Subject: FW: FW: Planning Consultation on: BN/57/20/DOC

Please upload onto Ocella the email trail below and the attachment from the **applicant** regarding discharge of condition application **BN/57/20/DOC** for the Lillies, Yapton Road, Barnham.

Outstanding comments

Condition 6 – Surface Water Drainage Design

17748-BARN-5-SK003 A

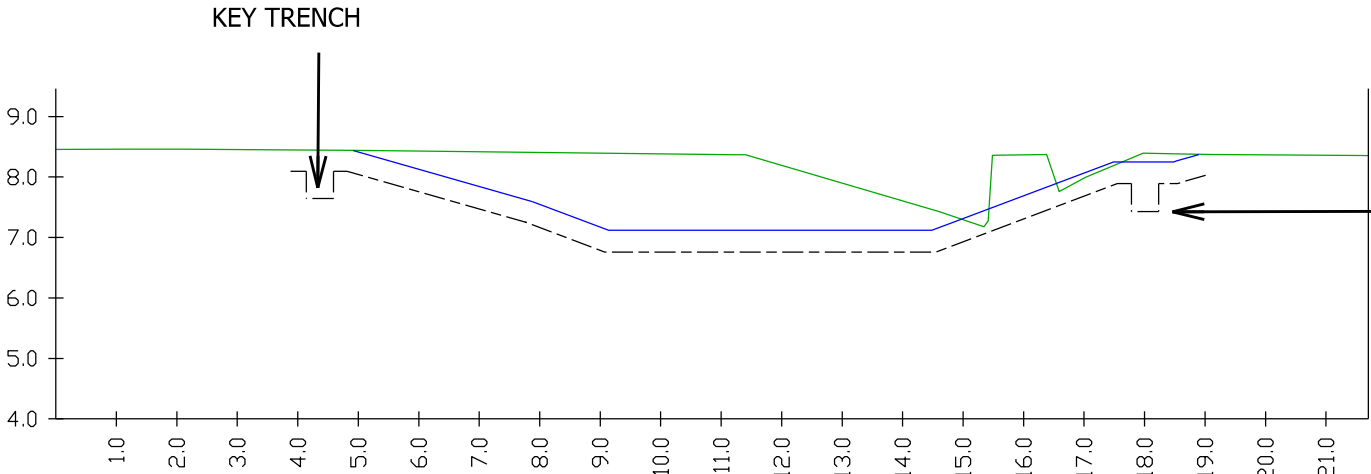
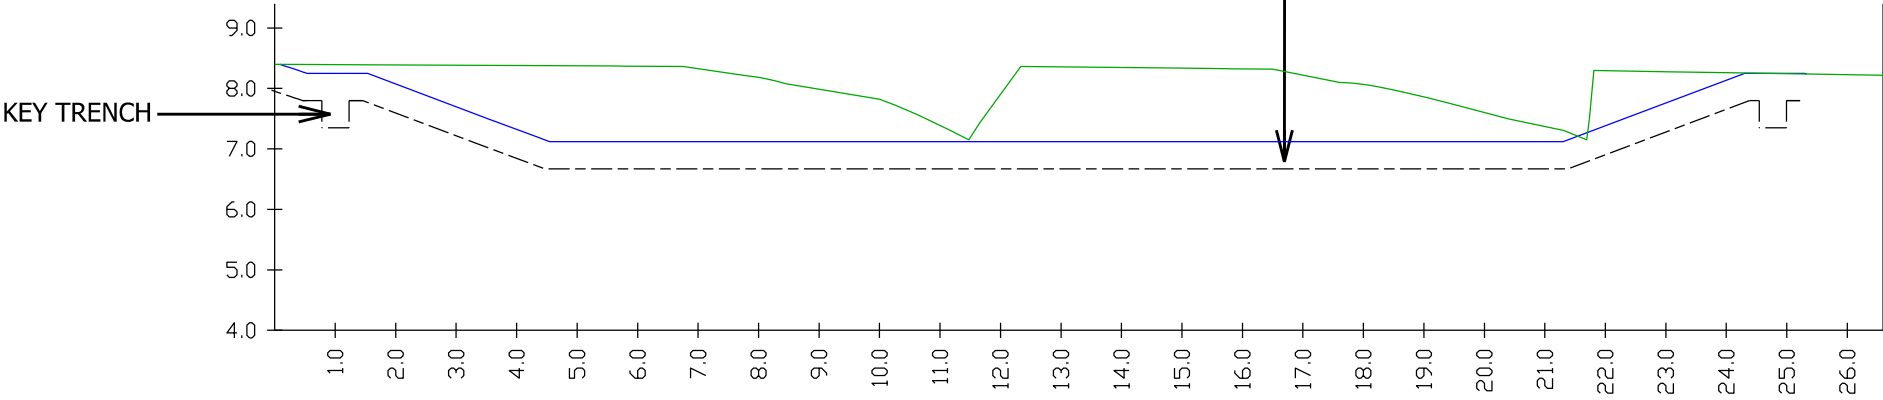
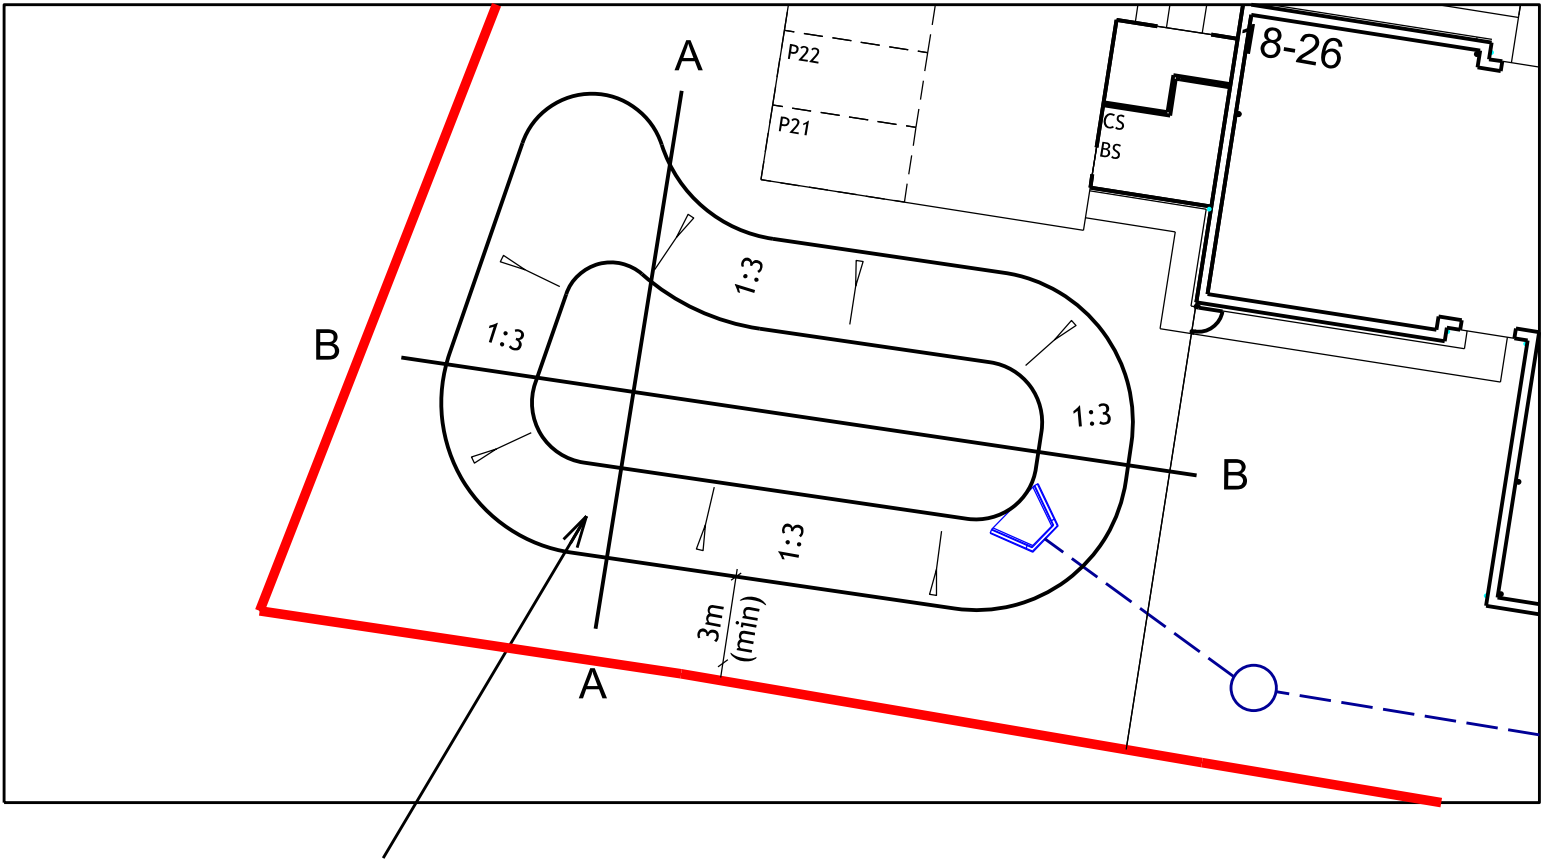
5. (Condition 6- 10) Please provide full flotation calculation detail. Showing depth of displaced ground water assumed, disturbing and resisting forces, factors of safety applied, etc. As indicated in our previous correspondence there is 250mm of ground water being displaced by 380mm of subsoil. This also assumes the pond is empty. The request for further calculations is simply not justified or appropriate.

10. Flotation calculations required. Please provide winter groundwater monitoring October- March. Otherwise, assume groundwater is at surface. Refer to the comments provided in the e-mail chain below. Please supply calculations. If monitoring has been completed October to March inclusive you can use observed groundwater levels, without this you must assume a worst case. You will note that in correspondence with Paul Cann he stated "Winter groundwater monitoring was undertaken on the development site immediately next door to the west. They encountered standing groundwater levels between 600mm and 1000mm deep which is comparable to our knowledge of Barnham. In fact levels can be much higher." Your attention is directed to where he states that in fact levels can be much higher, without full on site winter groundwater monitoring we cannot know how high levels will get, a worst case must be assumed, alternatively we are happy to wait for a full winters monitoring to be completed. The calcs provided to date already assume ground water level is at ground level: If you do assume a dry pond and groundwater at finished ground levels, you'll need sufficient soil above the liner to equal 188m³ of water (pond volume), ie 188 tonnes. With soil at 2 tonnes/m³ this means 94m³ of soil are required - for a 248m² pond area the soil thickness over the liner will need to be about 380mm thick throughout. Please provide the supporting calculations, I have not seen these to date. See green text. As previously noted the max GWL (i.e. top of ditch) is 7.37m AOD which is only 250mm above the pond IL. Therefore, specification of 380mm thick soil on top of the liner is more than sufficient.

Please provide full flotation calculation detail. Showing depth of displaced ground water assumed, disturbing and resisting forces, factors of safety applied, etc.
